Generic protection standards for unprecedented development

The Outline Soil Management Plan, Kent (7.5.10.2) and the Applicant's responses treat sensitive marsh soils of the former Wantsum Sea Channel in a generic manner. Development on a former sea channel that is now fresh water is unprecedented globally.

Plate 2.3 Infrastructure within fluvial flood extents

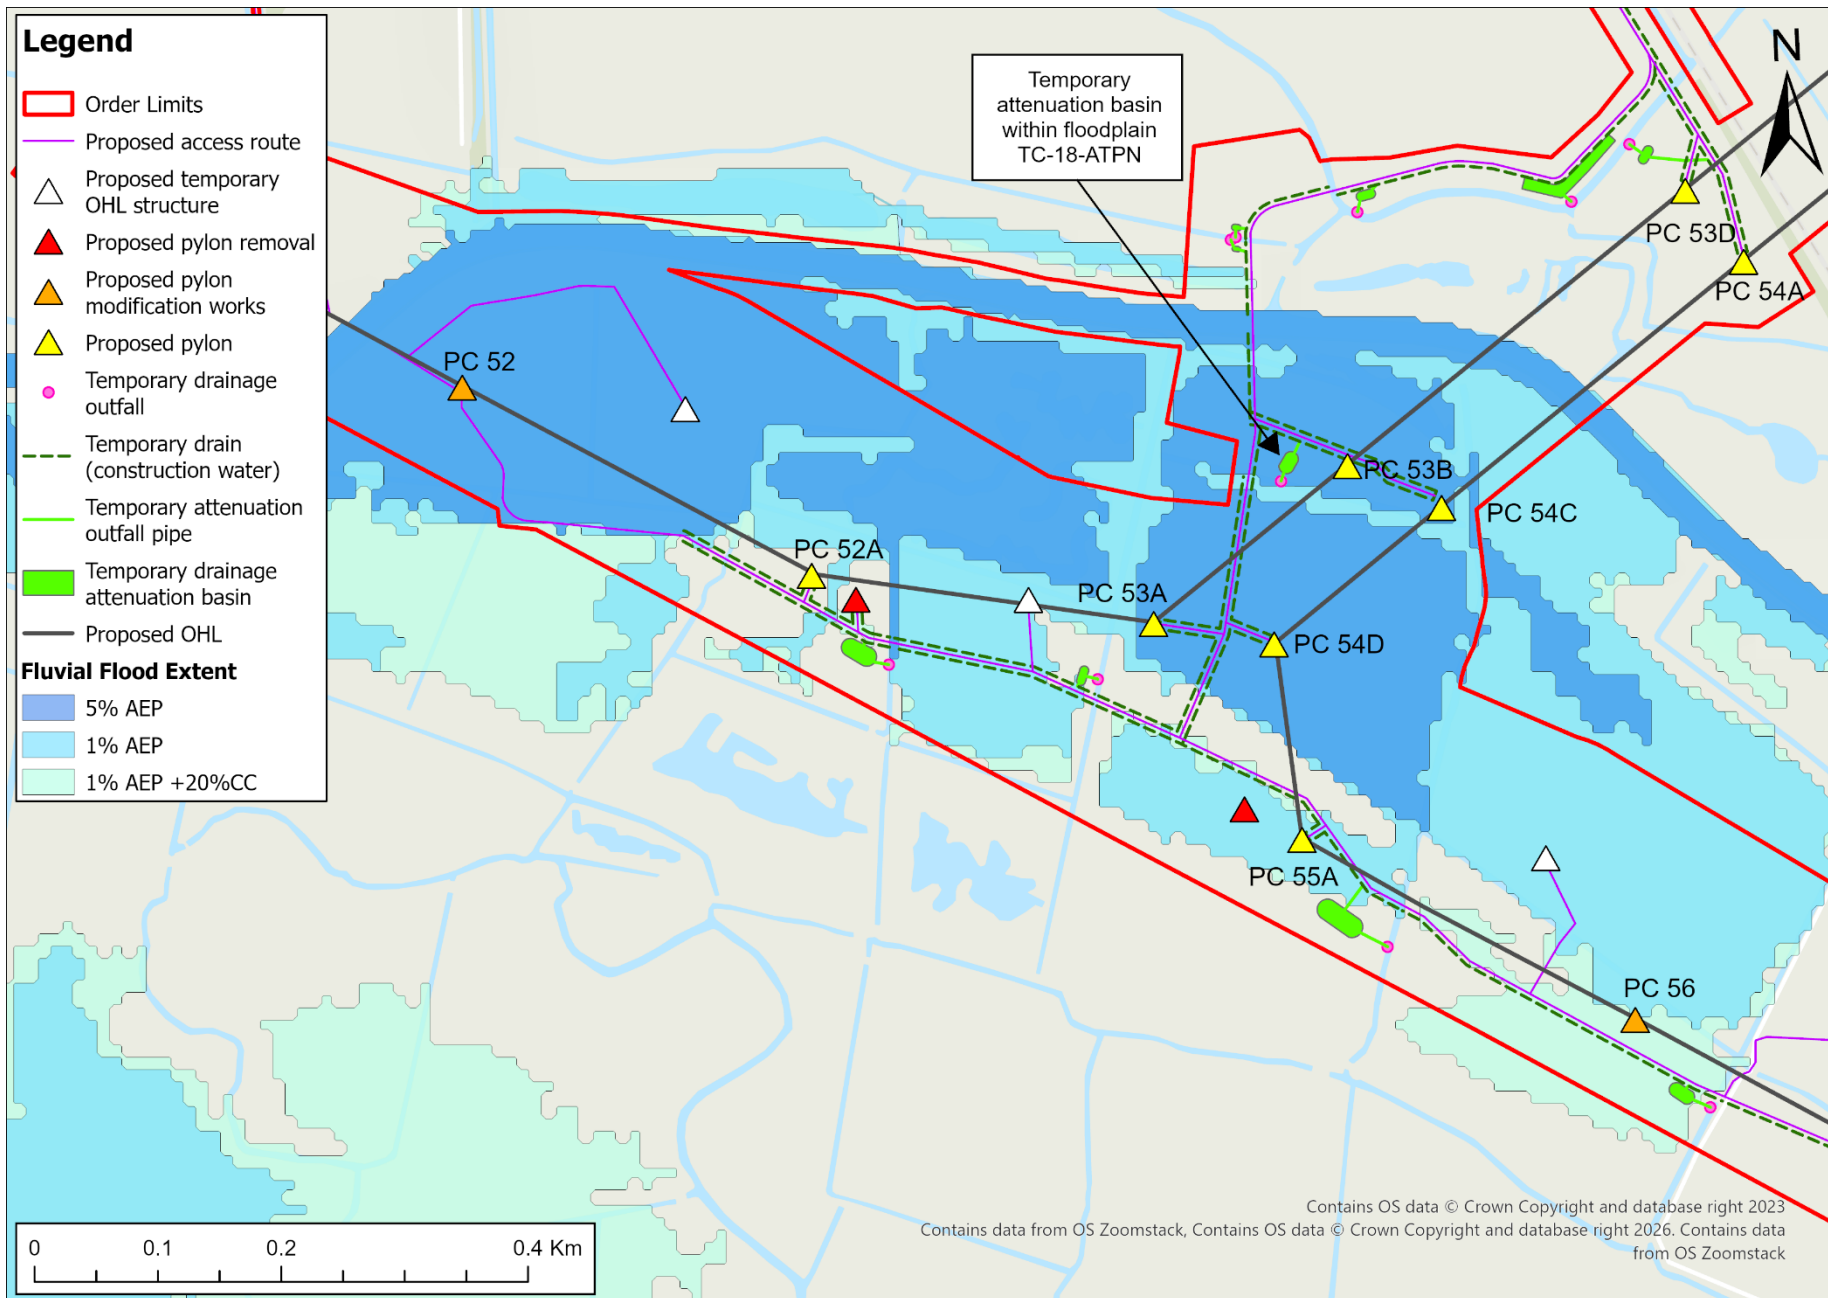
Attenuation pond sits directly over the Minster Stream

The Kent Drainage Strategy (9.17.2) and indicative plans (CR1-025) show permanent attenuation basins (including PC-09-ATPN and PC-11-ATPN) directly over the Minster Stream. This of course will not be possible to install, and there does not appear to be a practical place for the ponds to go.

Requirements:

Full details on how the drainage is proposed without collapsing banks of Minstr Stream. Reinstatement of soft alluvial soil that has been in min-till for 15 years will be returned to original condition following deep compression of water in anaerobic conditions?

How water will be removed from ponds when full to prevent flooding?
